KINCOPPAL – ROSE BAY SCHOOL OF THE SACRED HEART NEW SOUTH HEAD ROAD, ROSE BAY SSD APPLICATION – REVISED

RESPONSE TO SUBMISSIONS

PROPOSED ELEVATIONS -
WEST

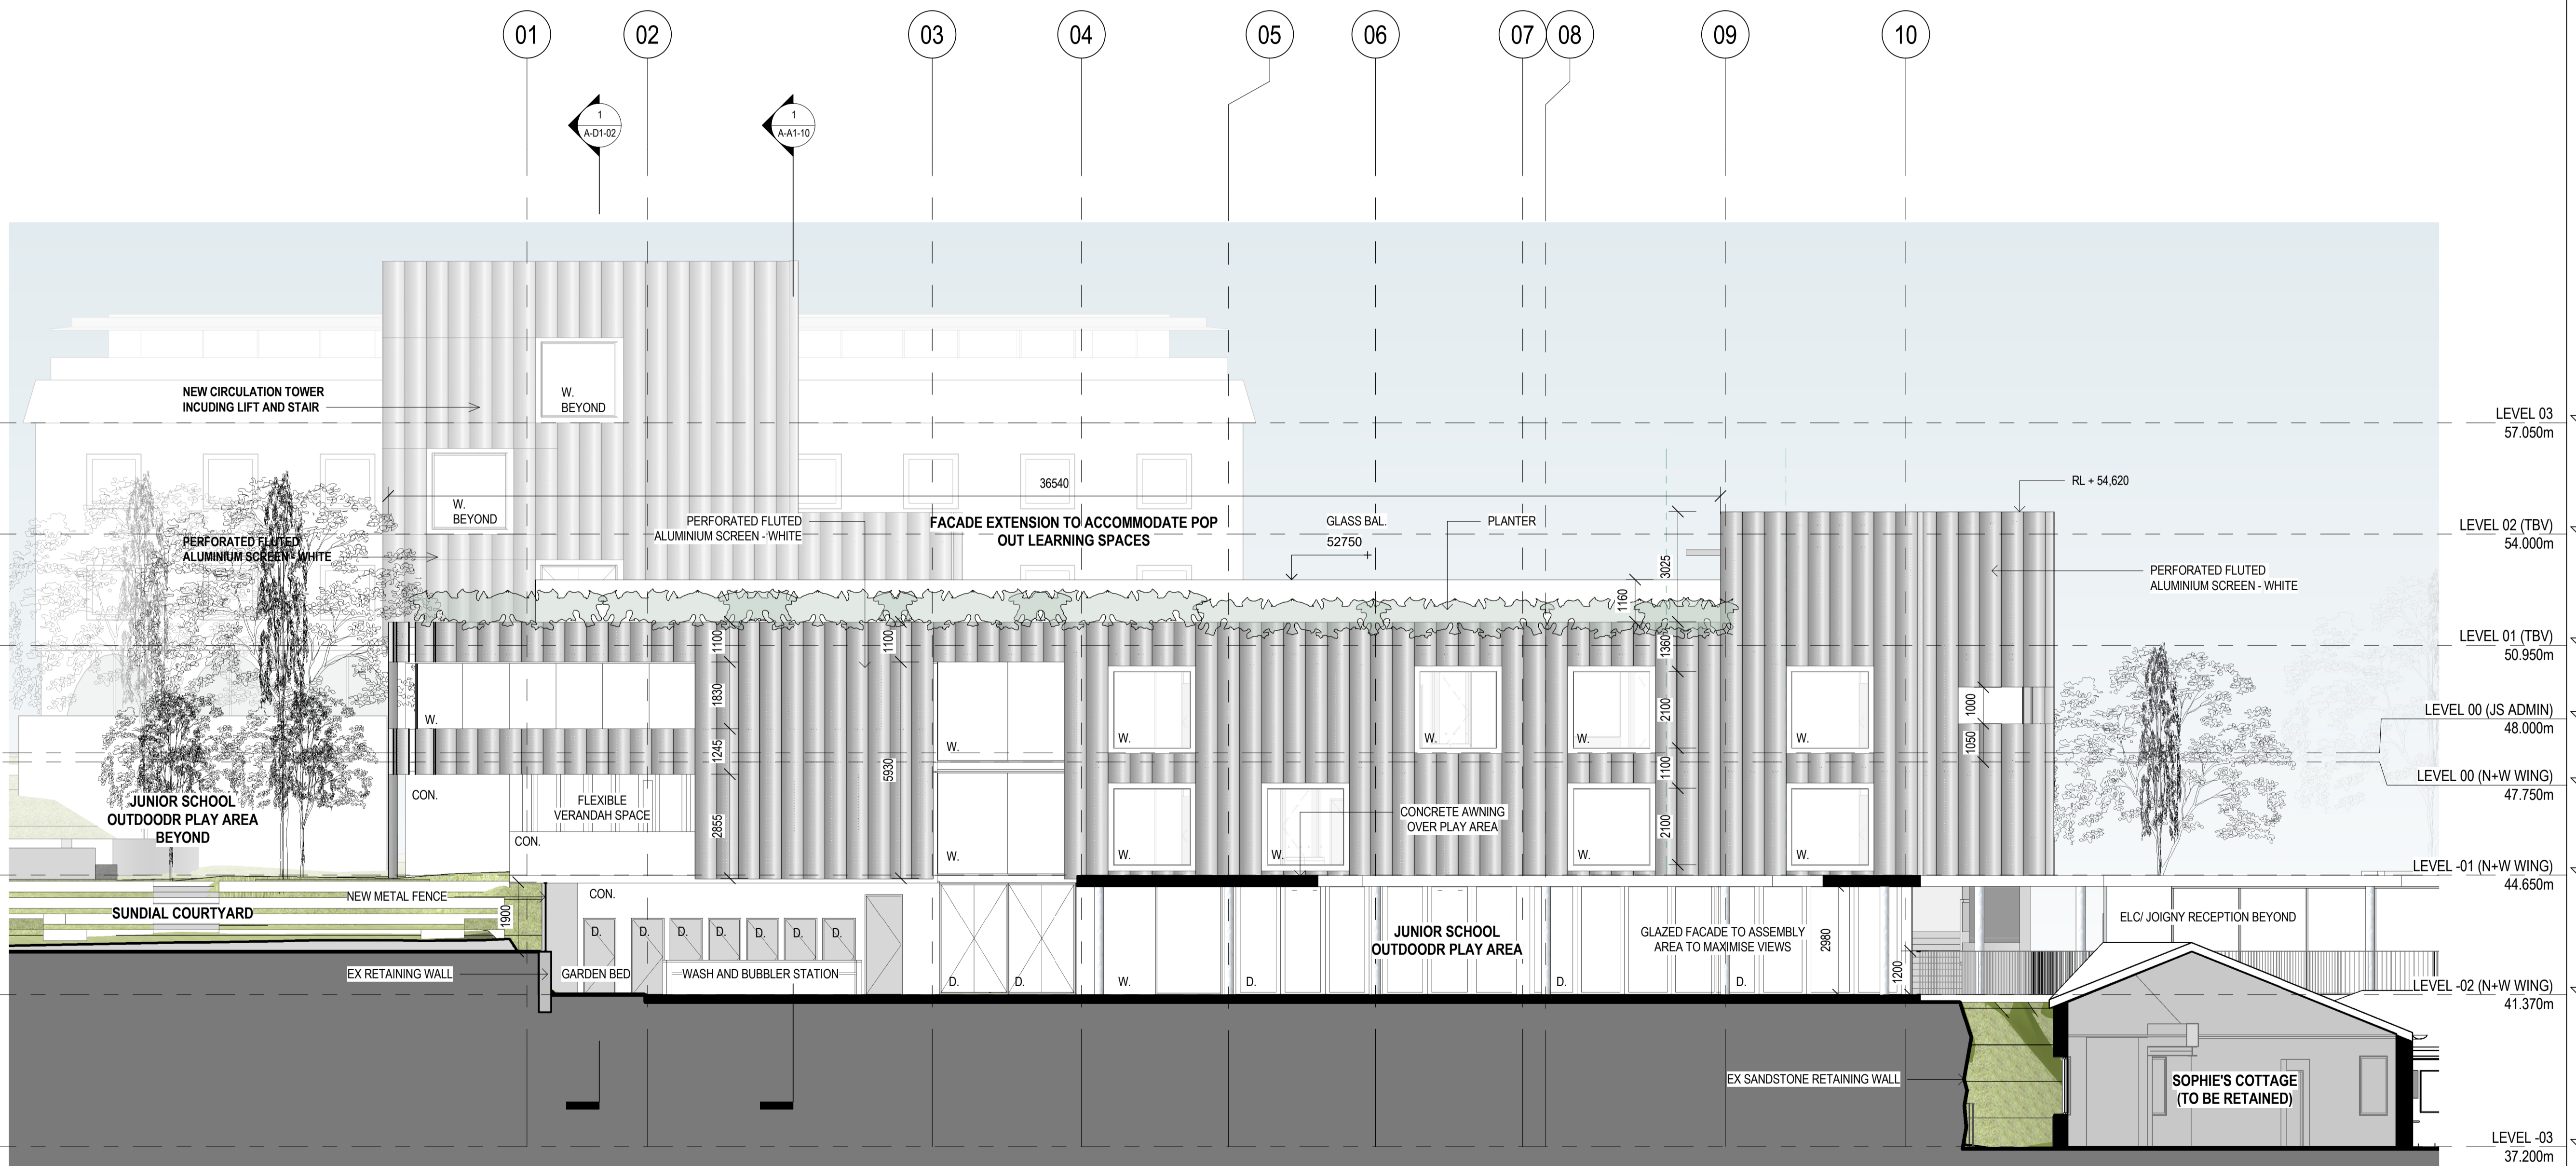
Precinct A – Concern is raised about the perceived bulk and scale of the proposed vertical circulation link. It should be redesigned to create a more articulated facade and enhance the transparency of the façade through materials and/or openings. This is to reduce its perceived bulk and scale and improve the façade visual interest, particularly when viewed from Sydney Harbour.

The agreed revised proposal reconfigures the stair internally to reduce the width of the masking element externally. This is described in drawings on pages 16, 21-26, and photo montages on page 55 of the BVN Design Report Issue E. This revised proposal is discussed below.

The stair above the roof terrace of the Junior School has been reoriented to present less width when

viewed from the west. To limit its projection to the west, the stair wall is now placed immediately adjacent the external wall of Barat Burn, bridging the void previously proposed. This section of the original blue brick wall will be concealed but remain intact.

When viewed directly west of this building, the existing circulation hub masks 2 window bays in addition to the bay used for access. The originally proposed hub masks 1 window bay for the lift, 3 with the stairs, plus 1 for access. The revised SSD proposed hub masks 1 window bay for the lift, 1 for the stairs, plus 1 for access.
